Re: Kelso Crescent Multi-Level Warehouse, Moorebank (SSD-58978472)

Liverpool City Council was invited to provide comments during the exhibition of a State Significant Development Application for a Multi-Level Warehouse at 20 Kelso Crescent, Moorebank (Lot 2 DP 521146 and Lot C DP 327378).

Attachment A – Detailed Comments

**SSD-06**

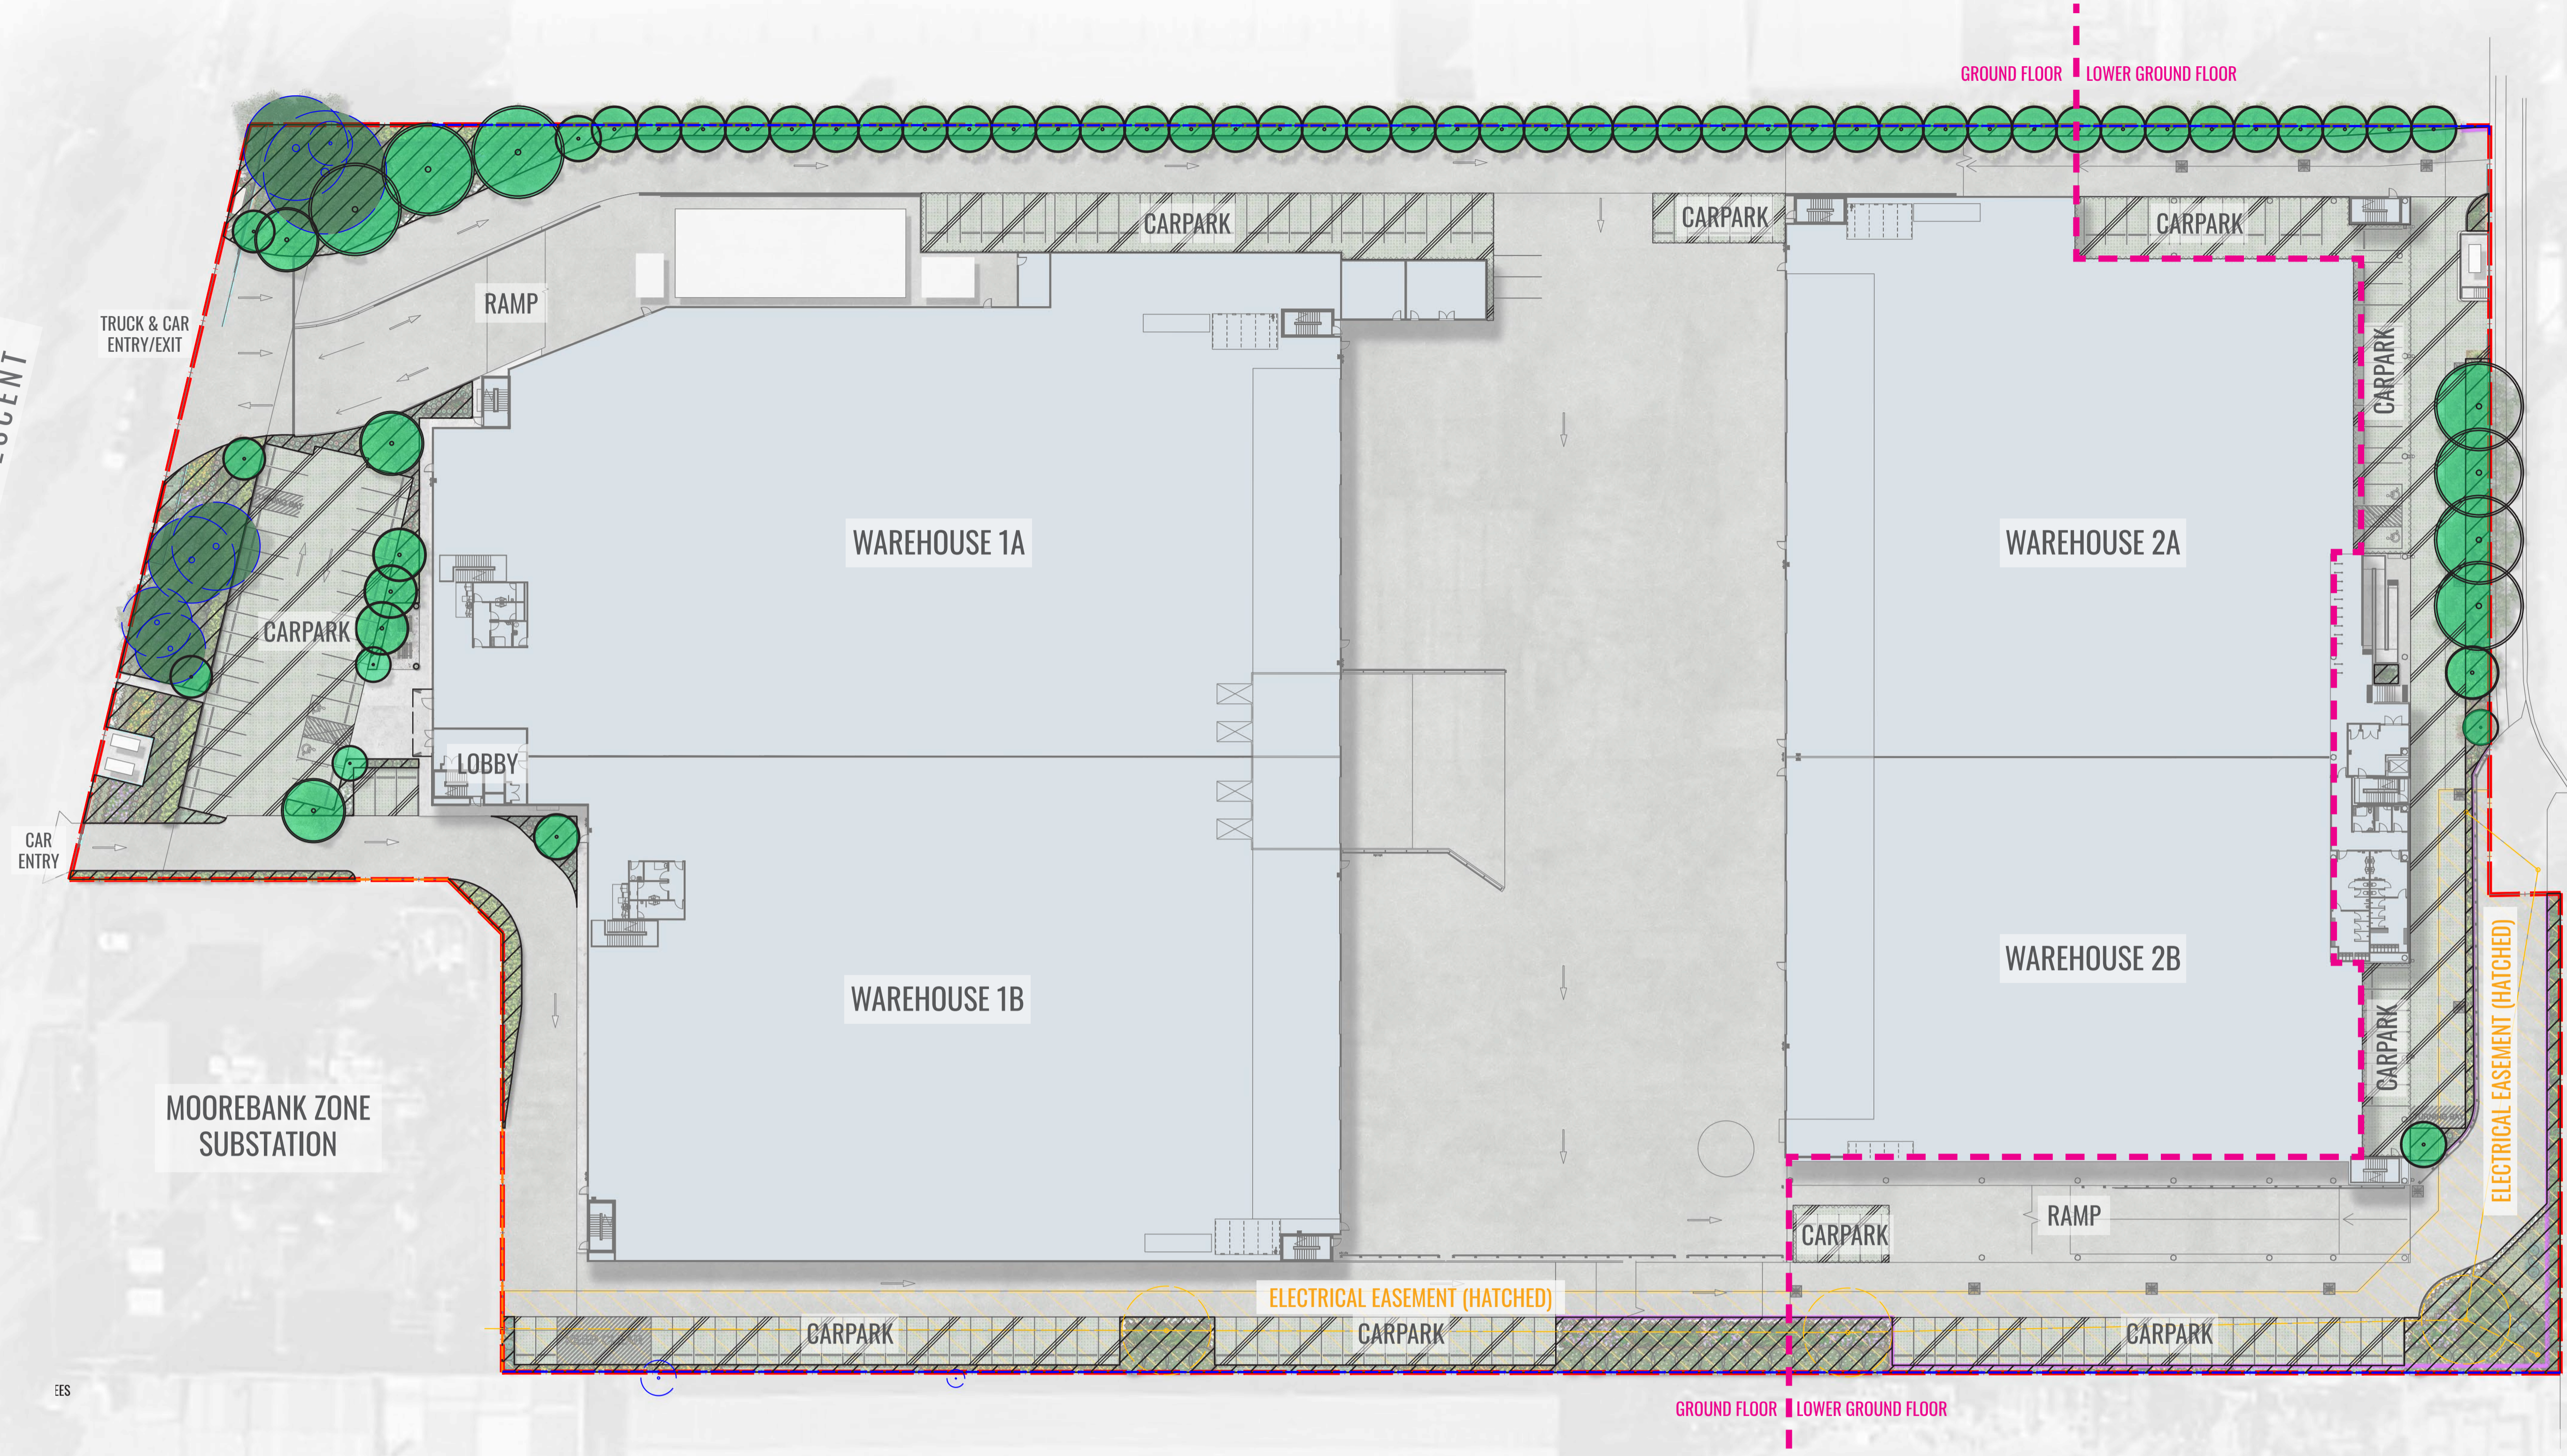
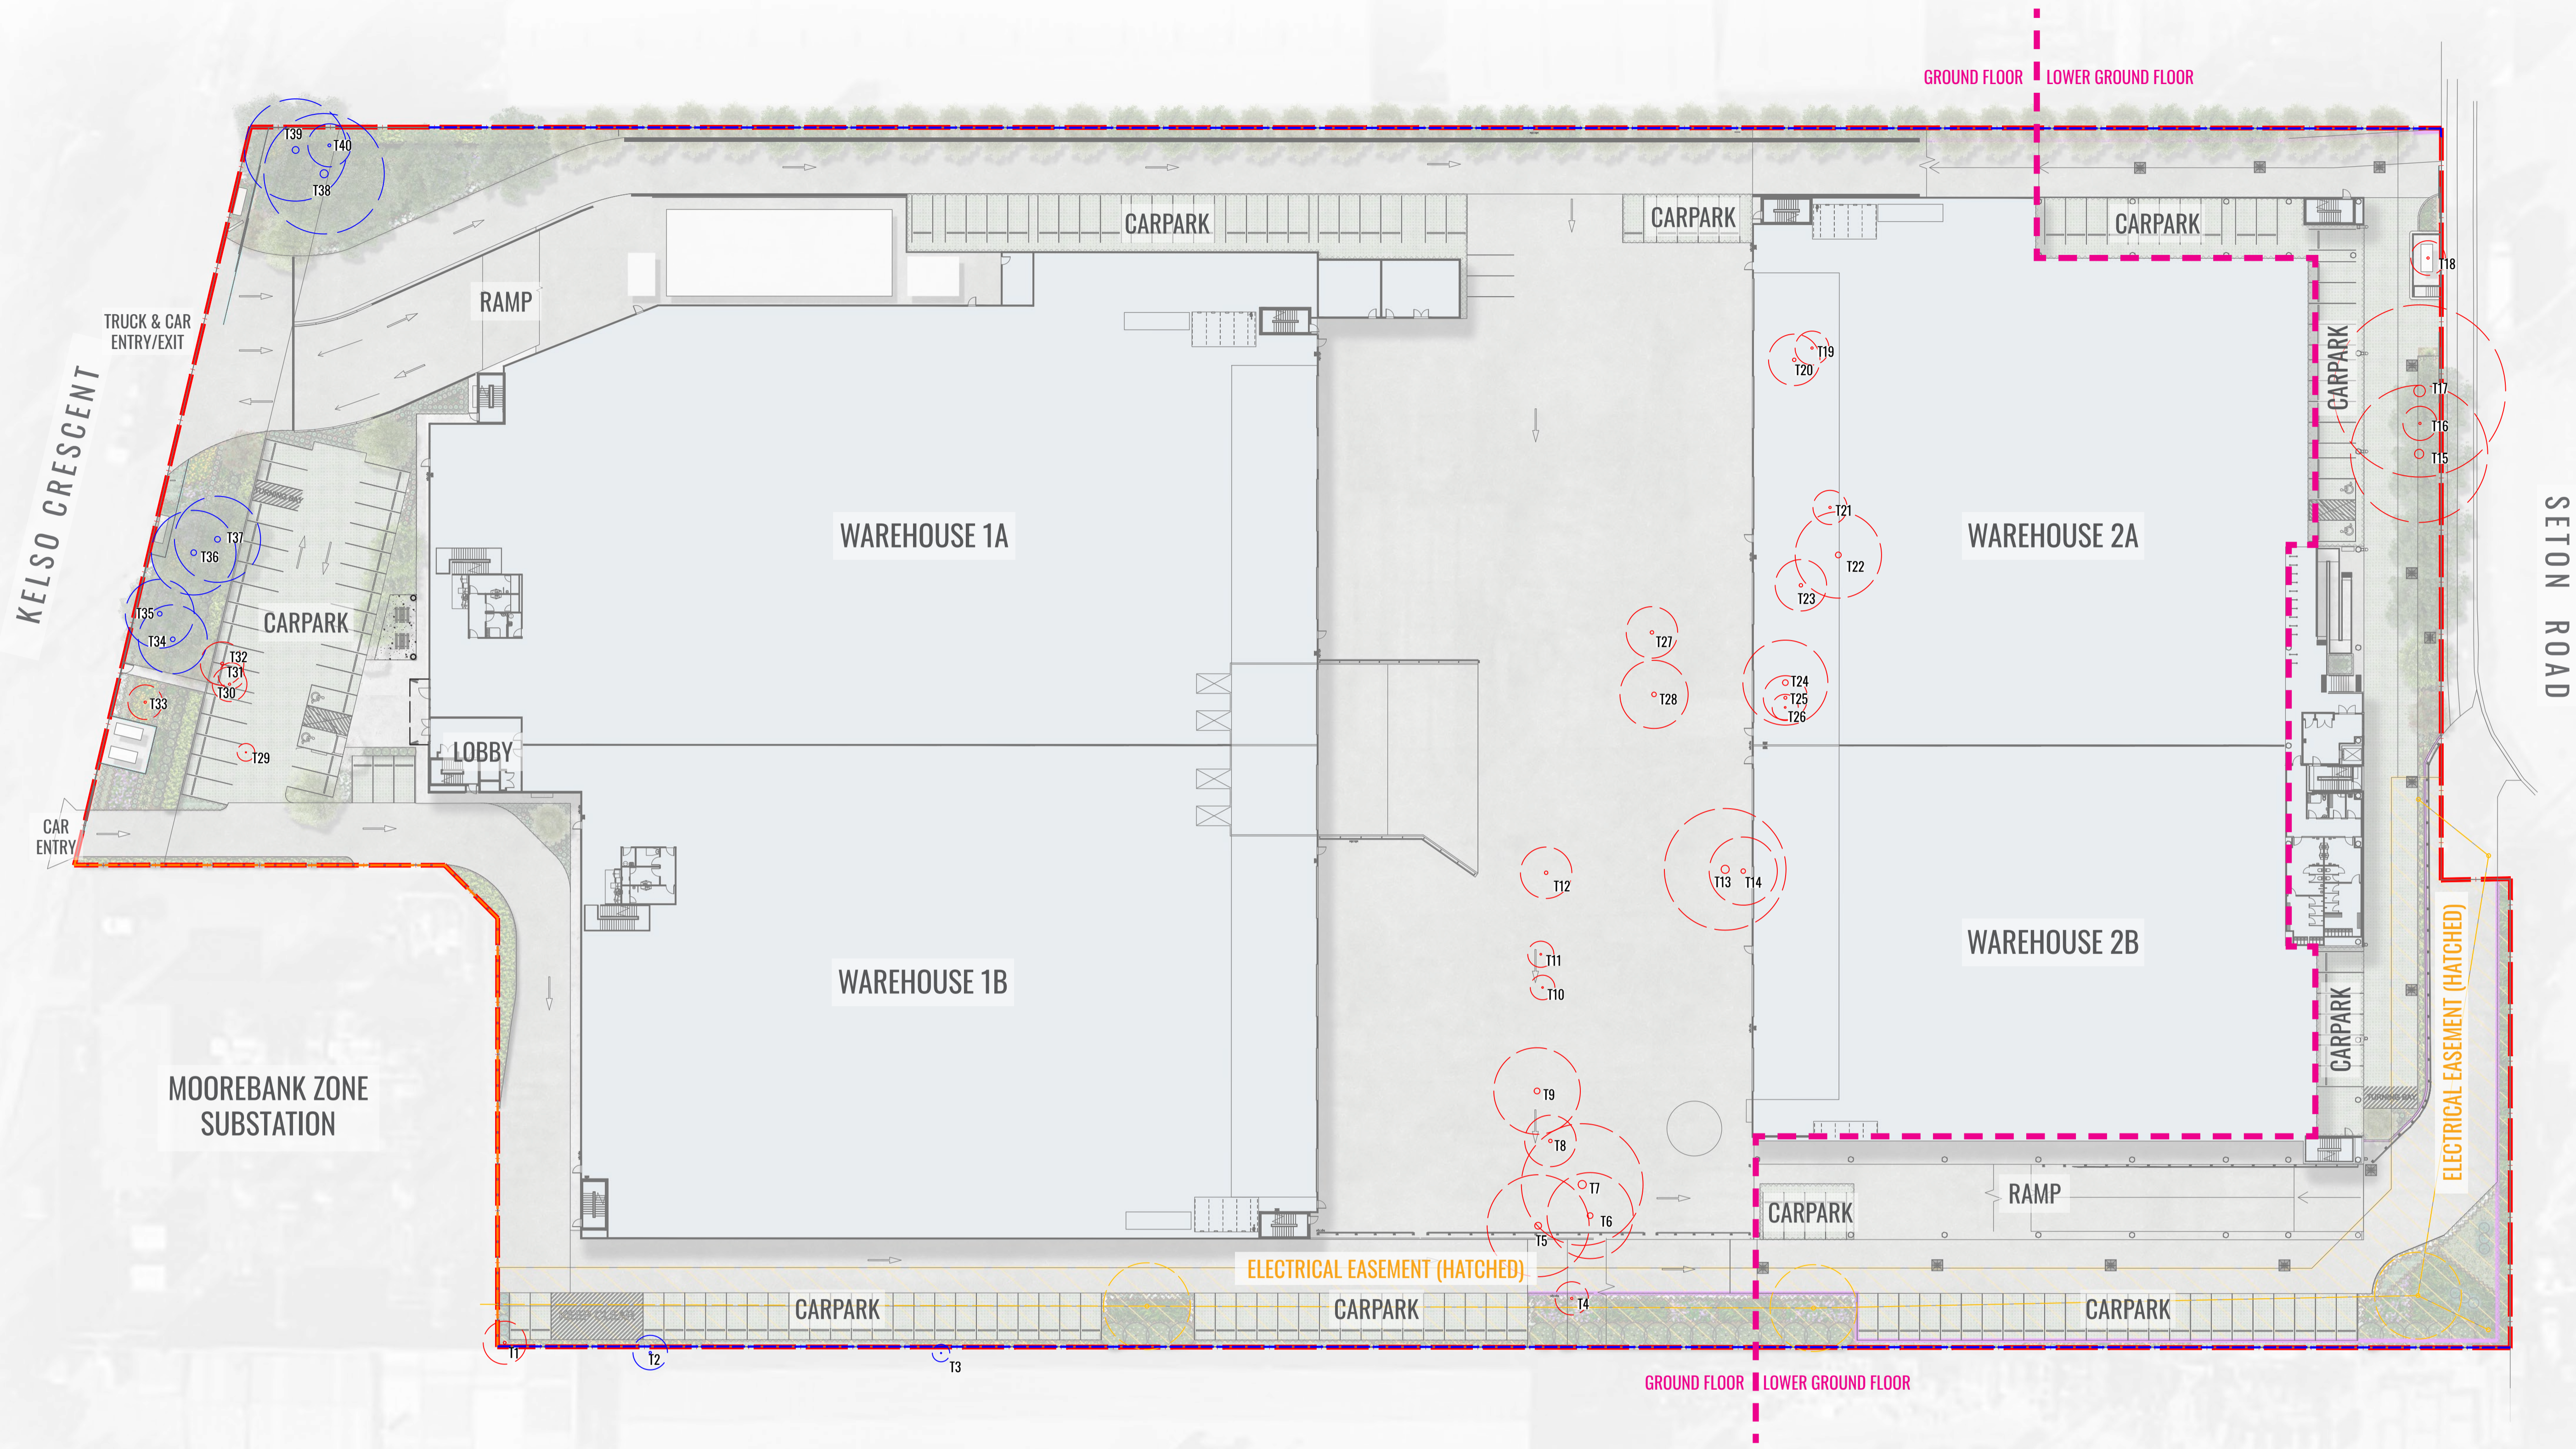
The landscape section AA and BB do not show the public domain, pedestrian footpath, street interface and kerbs adequately. This should also be included in the package. The fencing diagram also does not include fence heights. The applicant should provide fence heights in updated documentation and ensure consistency with the Liverpool DCP Part 7.

scale	As indicated	A1
project no	250211	
date	08.10.25	
dwn	DC	
dwg no	250211 - DA-113	
issue	A

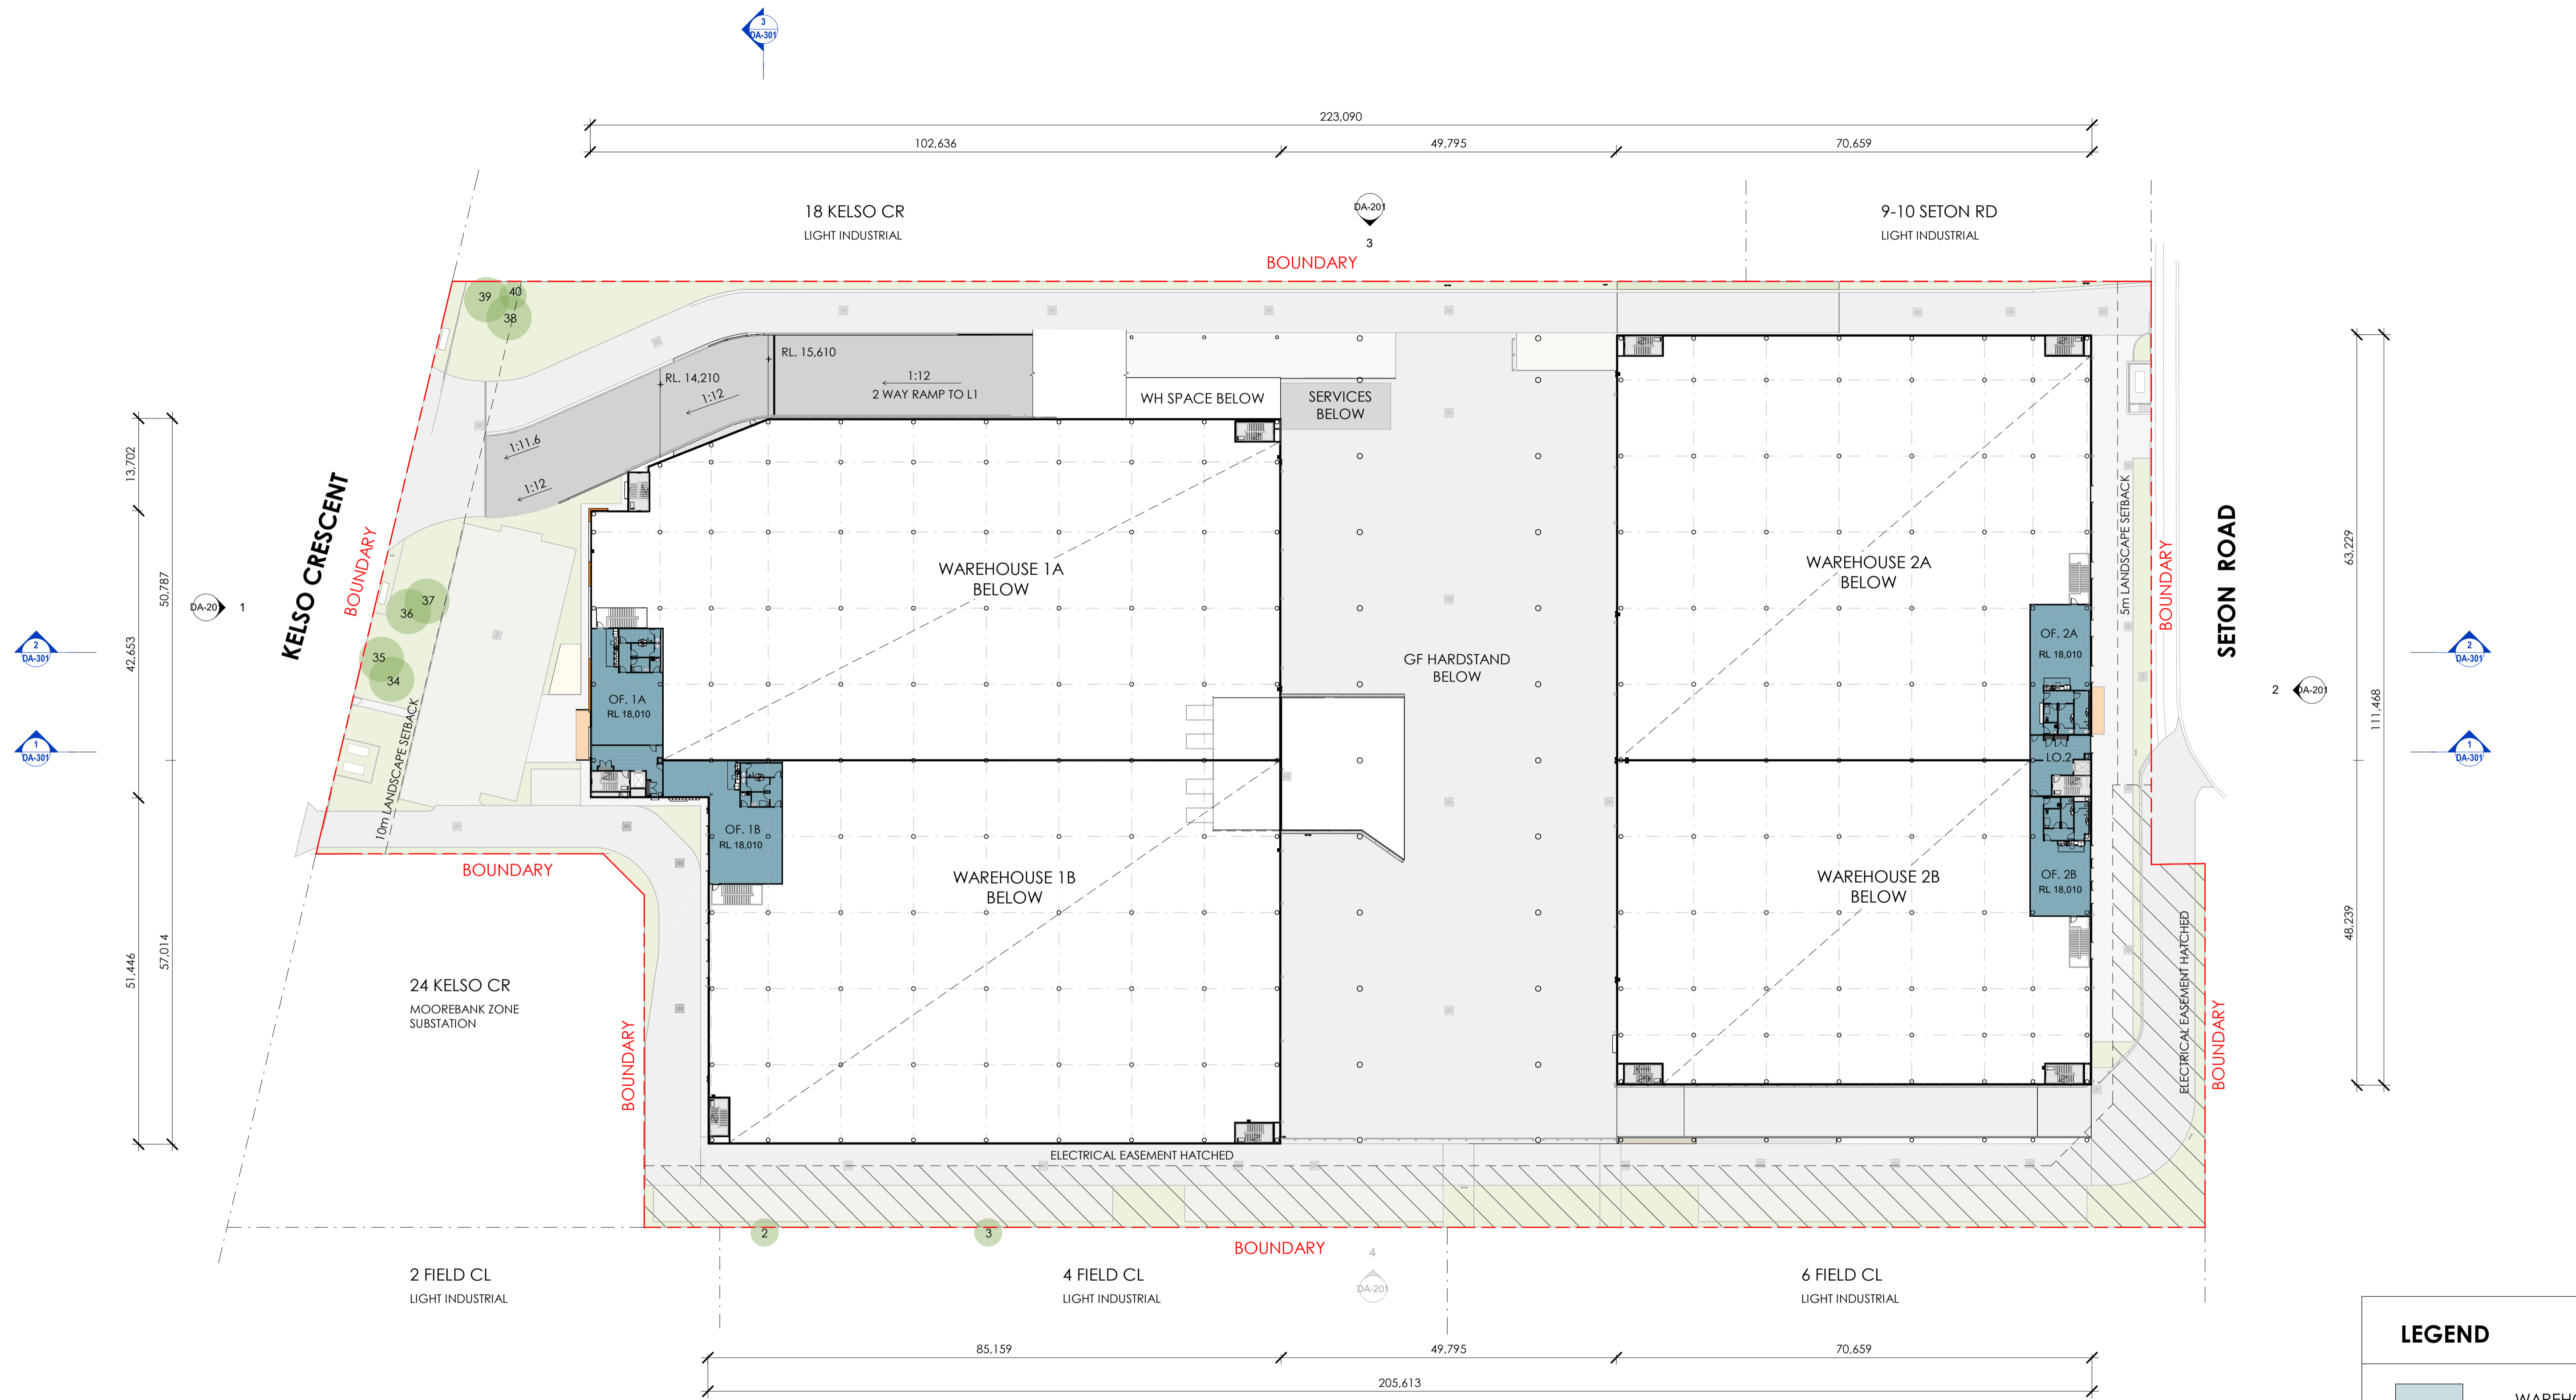
Based on the architectural plans, the first floor of the car park on the Kelso Crescent frontage is underground and not visible. There is therefore only one level of car park above the ground that is visible (shown on DA-113 Ground Floor Mez Plan), and of that level only a small portion of it is car parking with the remainder the wall to the main entry and amenities. On the elevations and 3D render however, there appears to be two levels of car parking above ground. Car parking on a street frontage is a poor urban design and amenity outcome. Council staff request clarification of how many levels of car parking are visible from the street interface, and drawings should be updated accordingly to resolve any inconsistencies or missing details.
